Final Plat - Comment Response Letter

Citizen on Constitution  
El Paso County, Colorado

PCD File Number: SF-226

**AKERS DRIVE CD'S – PCD ENGINEERING  
COMMENT RESPONSE**

AKERS DR & ACCESS ROAD ROUNDABOUT  
EL PASO COUNTY, COLORADO  
ROADWAY CONSTRUCTION DOCUMENTS  
ROADWAY PLAN

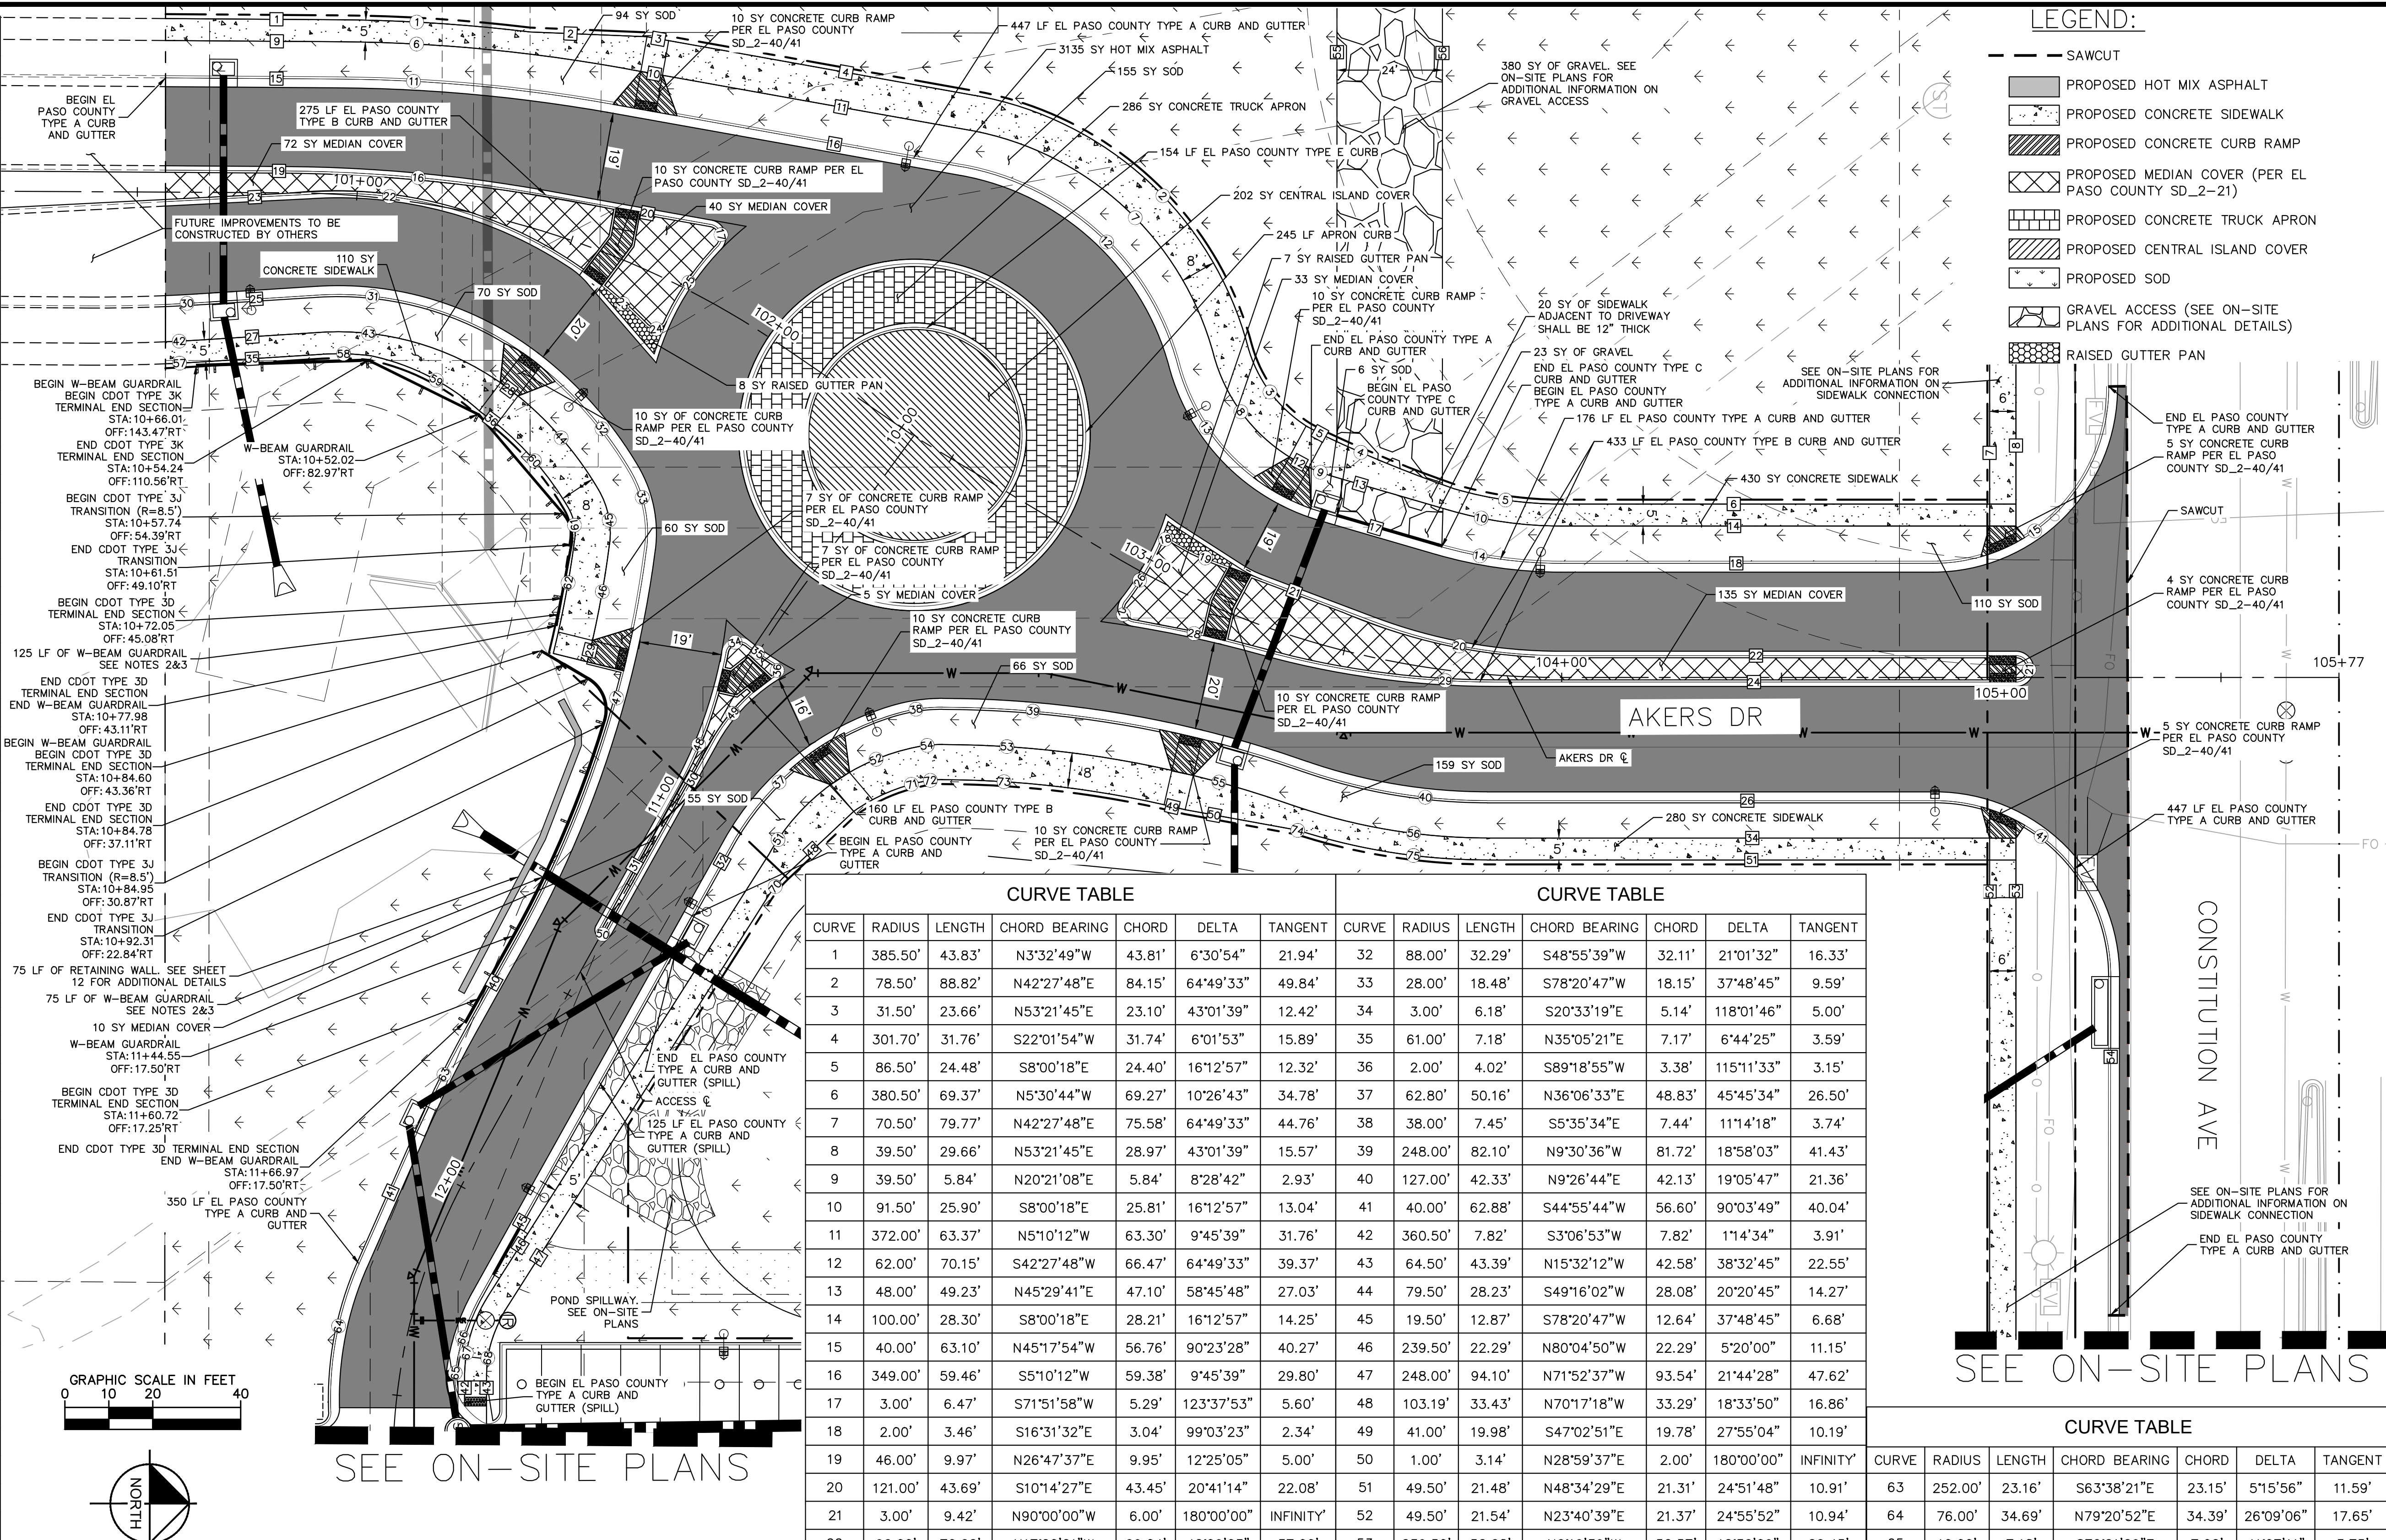
Review 3 comment: provide lane widths at entry and exit of roundabout and at travel lane around the roundabout.  
Review 4: Please provide the width of the travel lane at the roundabout

Review 2 comment: Please extend construction drawings to where the sidewalk will tie into the adjacent properties sidewalk along constitution.  
Review 3: Unresolved.  
Review 4: Unresolved. All construction that is required to be performed with the final plat shall be provided in the construction drawings associated with the final plat. Please provide CD's for the sidewalk to be constructed along Constitution.

A transition is needed from the vertical curb/inlet to the ramp curb. revise the inlet/emergency access/ramp accordingly so that this works.

**SHEET ADDED ROADWAY PLAN 2 (11) TO COVER SIDEWALK EXTENSIONS TO THE WEST AND EAST. LINE TABLES UPDATED ACCORDINGLY.**

**DIMENSION ADDED TO THRU LANES**

**THE EMERGENCY ACCESS WAS SHIFTED TO PROVIDE ROOM FOR A CURB TRANSITION.**
